**KIRKLEES METROPOLITAN COUNCIL
INVESTMENT & REGENERATION SERVICE**

Reference No:	2023/62/91595/W
Site Address:	690, Bradford Road, Fixby, Huddersfield, HD2 2JY
Description:	Erection of two storey side and single storey rear extensions with integral garage and external alterations
Recommending Officer:	Lucy Taylor

DECISION – REFUSED

Officer Report.

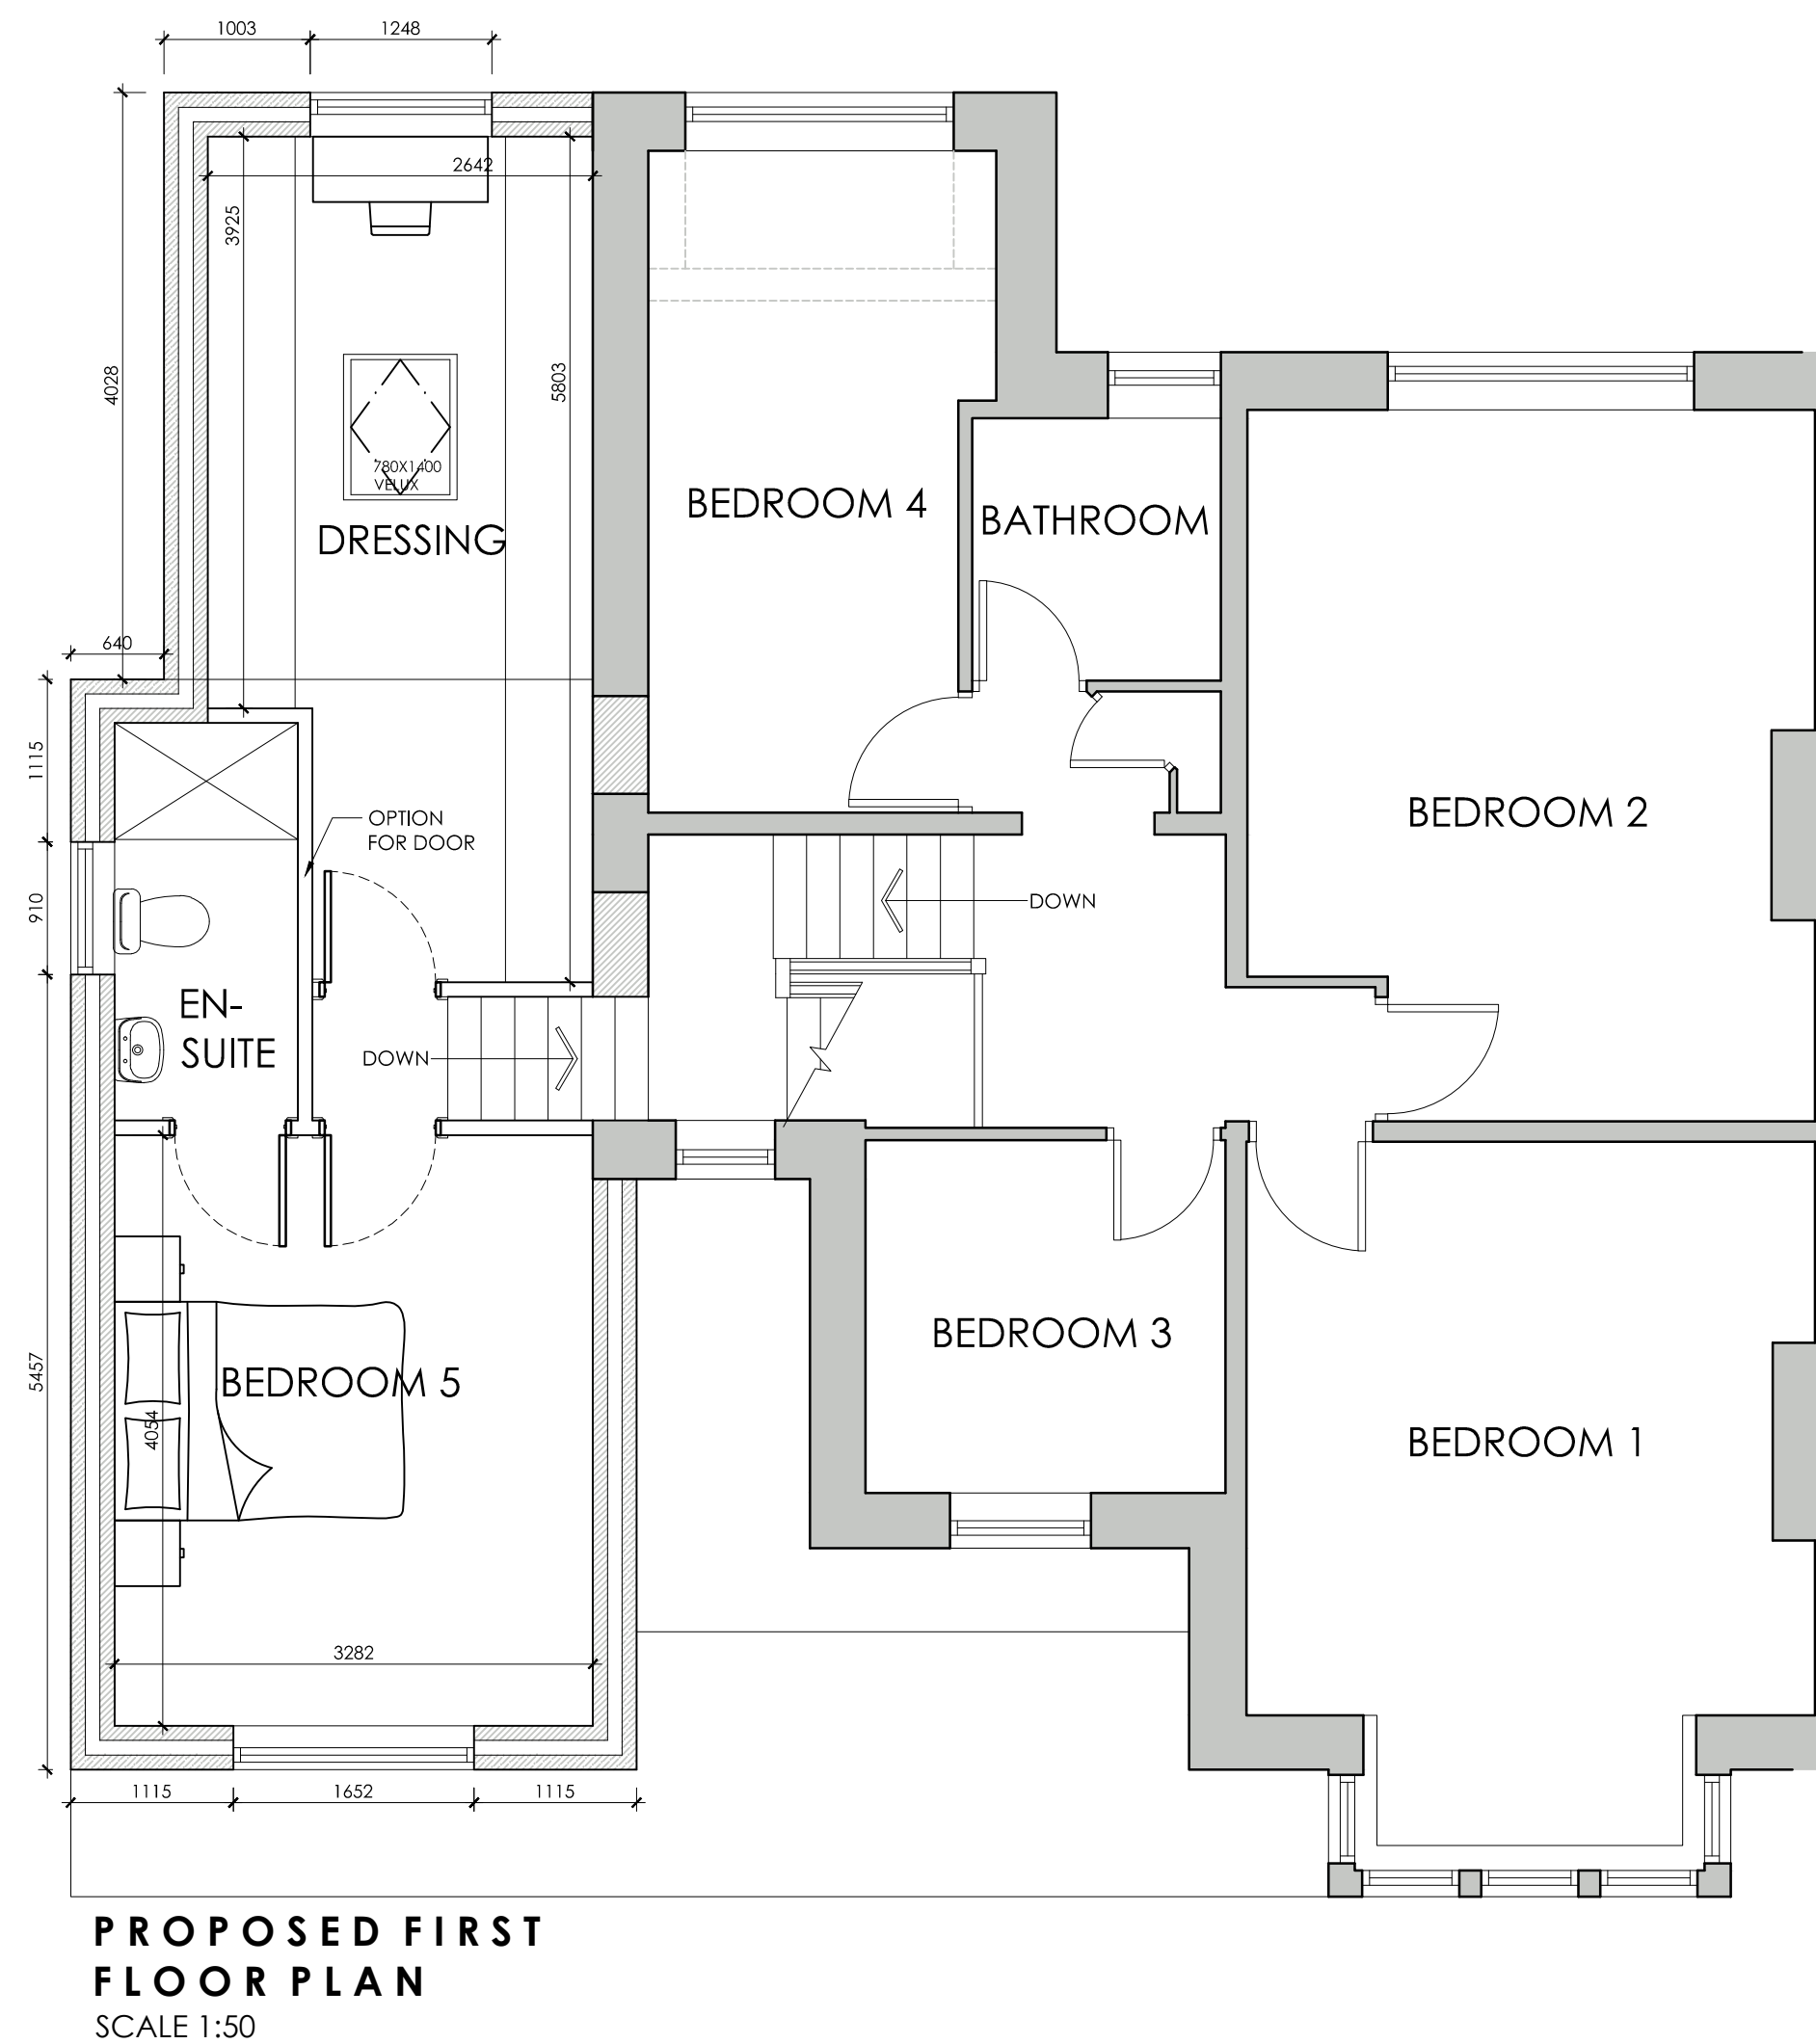
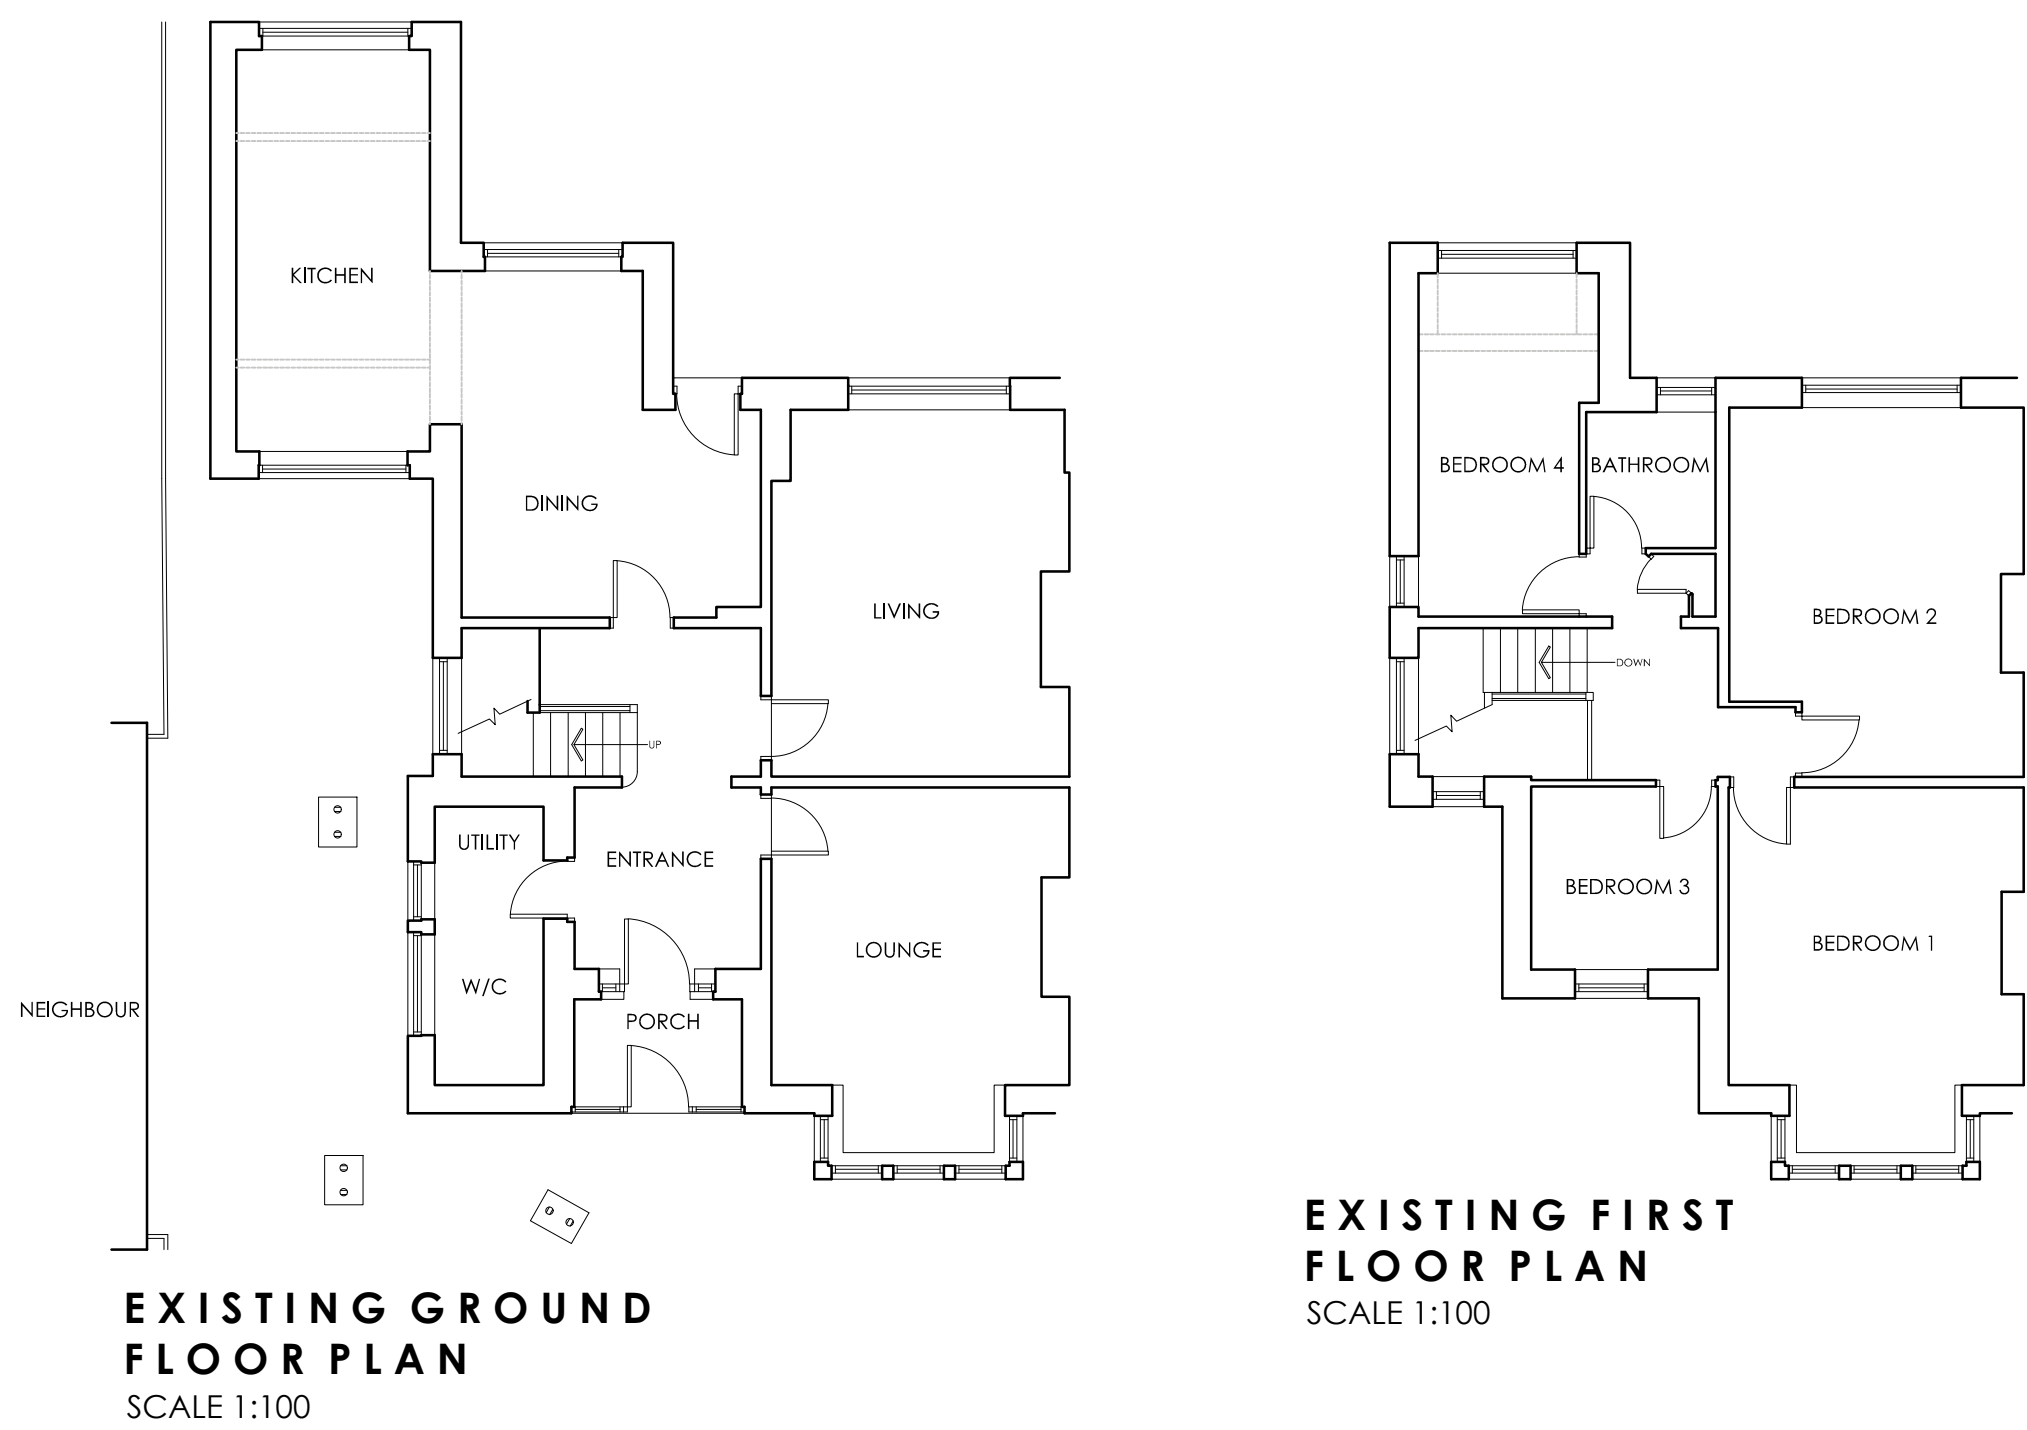
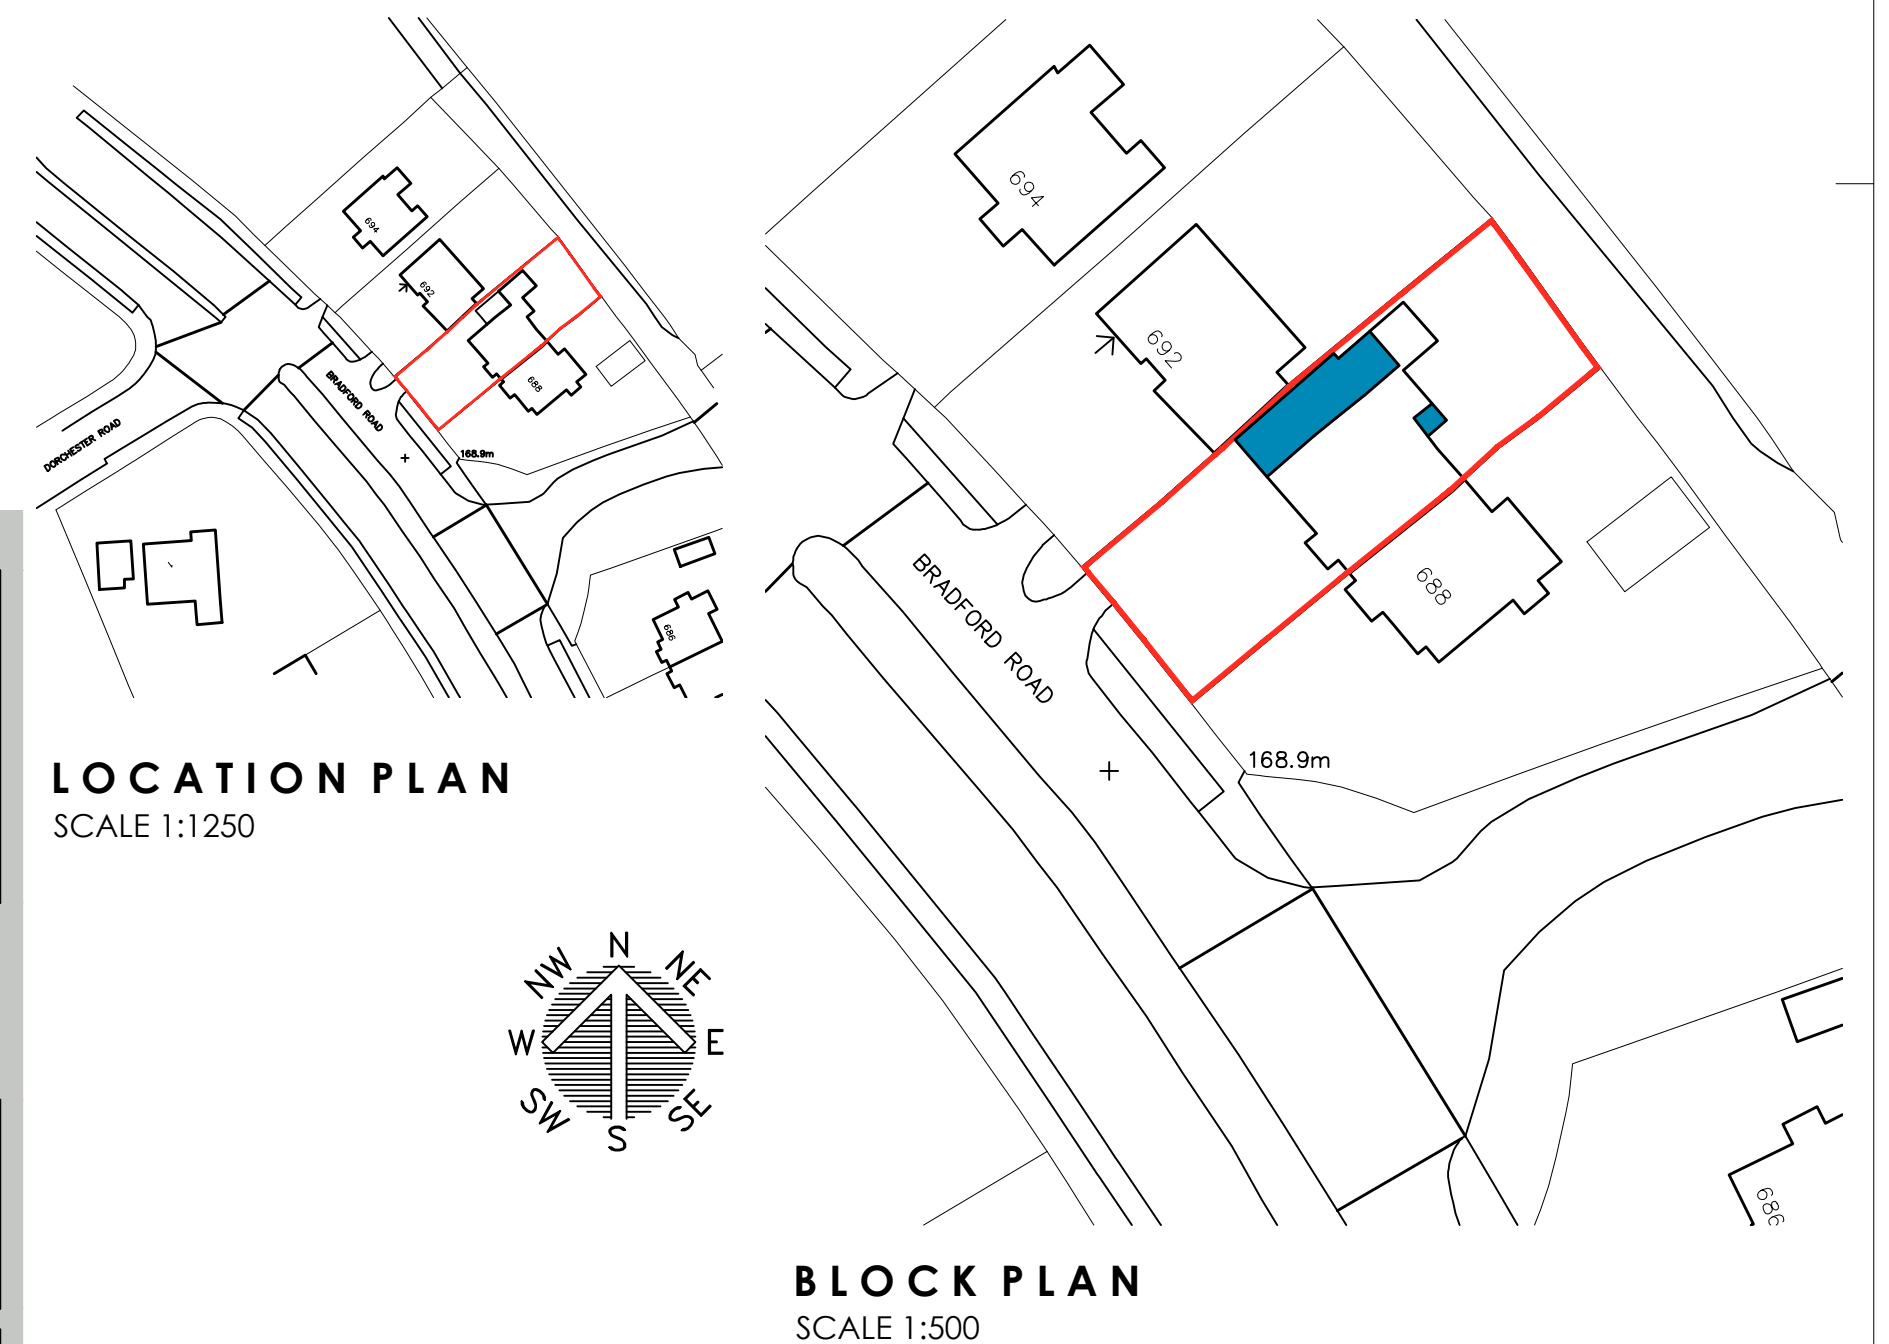
The proposed two-storey extension to 690 Bradford Road would not be considered to be subservient to the host property with regard to its size/scale, nor would its design or sitting be in keeping with the requirements of the House Extensions and Alterations SPD as set out above.

The proposed two-storey side extension would be considered to take up all of the space to the side of the host property. Whilst officer's note that the rearward section of the extension retains a small gap from the shared boundary, towards the front, the extension meets the side boundary of curtilage for a length of 5.5 metres. This would close the gap between the site and neighbouring property, causing a negative impact on the appearance and character of the street scene and posing detrimental potential for a terracing effect to be created along a non-terraced street.

It should be noted therefore, that the erection of the proposed two-storey extension would result in the loss of external access to and from the front and rear of 690 Bradford Road.

In addition, the proposed two-storey extension presents an undue extent of bulk and massing, failing to be set back from the principal elevation of the host property to any degree and failing to be set down from the roof pitch of the host property. In turn, the proposed two-storey side extension fails to be visually smaller in relation to the original house of 690 Bradford Road and would appear as unproportionate in scale.

The street is characterised by dwellings in spacious surroundings, it is considered the design of the proposal would impact upon the character of this part of the street as a result of its dominant design which would increase the massing / built form of the host property in a non-subservient manner which would not be harmonious to the character of the street.

For these reasons, it is concluded that the two-storey extension would be an unsympathetic addition to the host property of 690 Bradford Road. In addition, the proposed two-storey extension poses detriment to the established visual character of the wider locality. It is therefore concluded that the development scheme as applied for would not comply with policies within Chapter 12 of the NPPF, policies LP1, LP2 and LP24 of the Kirklees Local Plan or Key Design Principles 1 or 2 of the House Extensions and Alterations SPD.

1. The design, size and scale of the proposed two-storey side extension would not be subservient to the host property, and would result in an undue level of bulking and massing. The proposal is not considered to be harmonious with, and therefore causes detrimental harm to, the character of the host property and wider locality contrary to Policies LP24 of the Kirklees Local Plan, Key Design Principles 1 and 2 of the House Extensions and Alterations SPD and policies contained within Chapter 12 of the National Planning Policy Framework.
